WEST SUSSEX COUNTY COUNCIL CONSULTATION

TO:	Arun District Council - FAO: Simon Davis
FROM:	WSCC - Highways Authority
DATE:	16 September 2021
LOCATION:	Sefter Farm, Pagham Road, Pagham, PO21 3PX
SUBJECT:	P/117/21/PL Construction of a new packhouse including relocation of parking area and landscaping. This site may affect the setting of a listed building and is in CIL Zone 5 (Zero Rated) as other development.
RECOMMENDATION:	More Information

Figure 3.2 – Visibility splays commensurate with 20mph speed limit

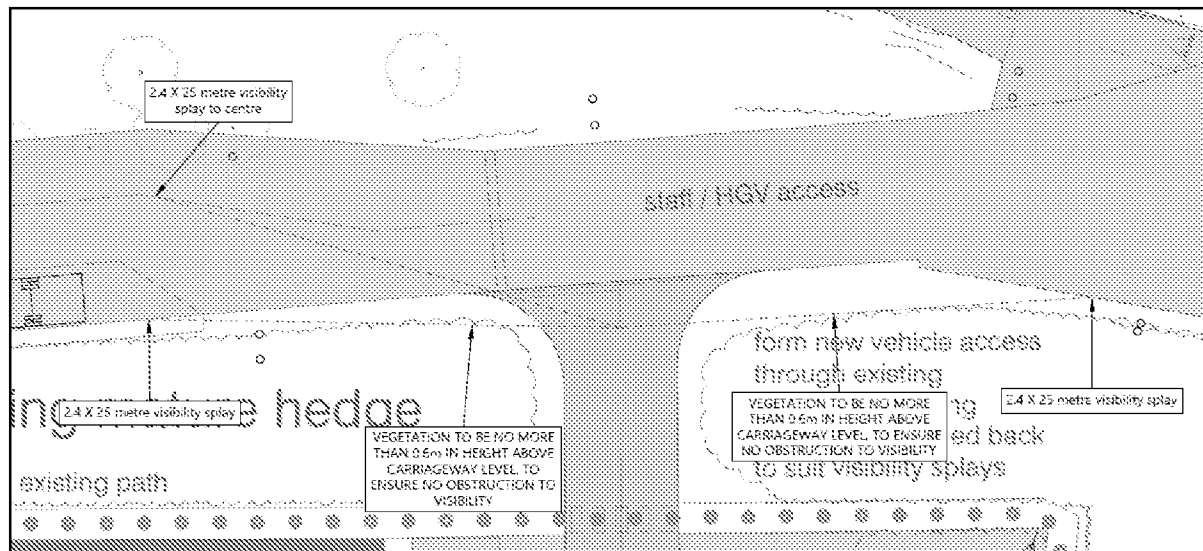
The existing car park will be relocated and visibility splays of 2.4m by 25m (20mph) from the car park access to the internal site road have been demonstrated. Tracking shows that cars can manoeuvre within the car park and pass in the access. It is stated that 219 spaces exist at the site in total although 190 are provided in the relocated car park it is not clear where the additional 29 spaces are located. Whilst it is noted that no new staff are proposed, it would be useful for each existing and proposed building floorspace to be set out against the required parking standard. It would also be beneficial to understand proposed storage only floor area of the new building and justify how the amount of space provided will meet all storage needs on site omitting third party movements.

Architect's Illustrative Site Layout

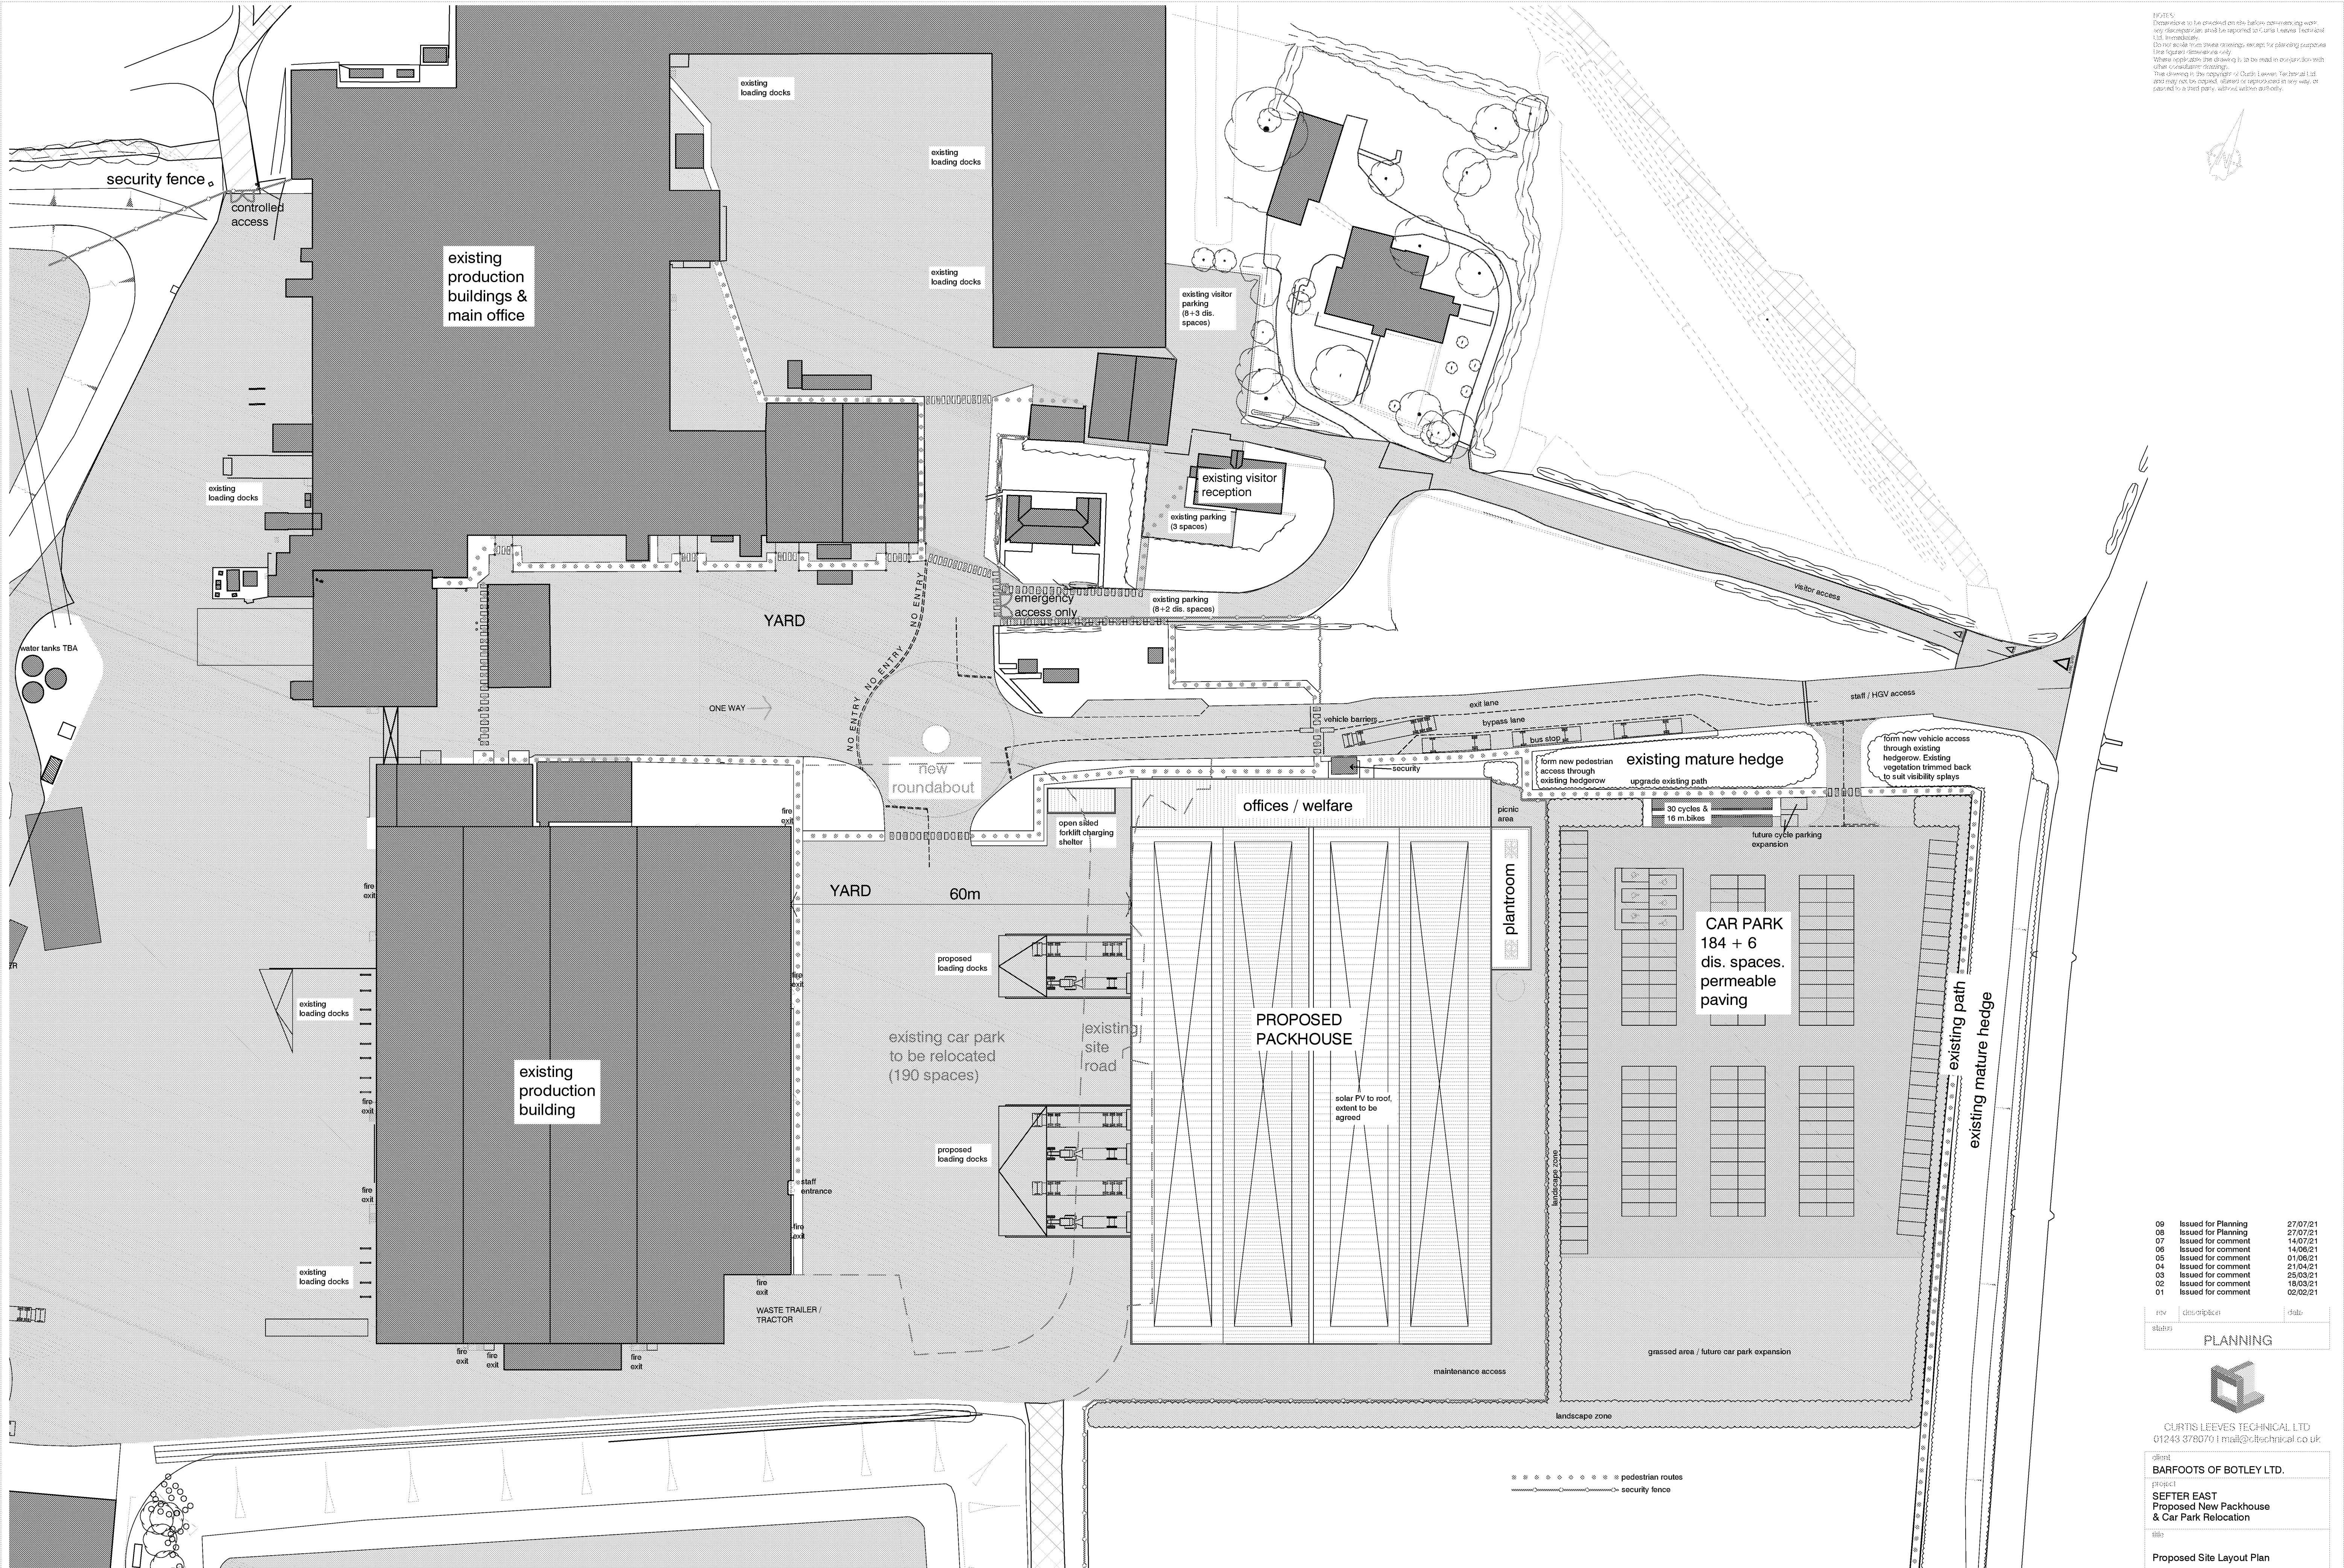
To understand the rearrangement of storage on site and impact on vehicle routes it would be useful for plans to show HGV routes throughout the site.
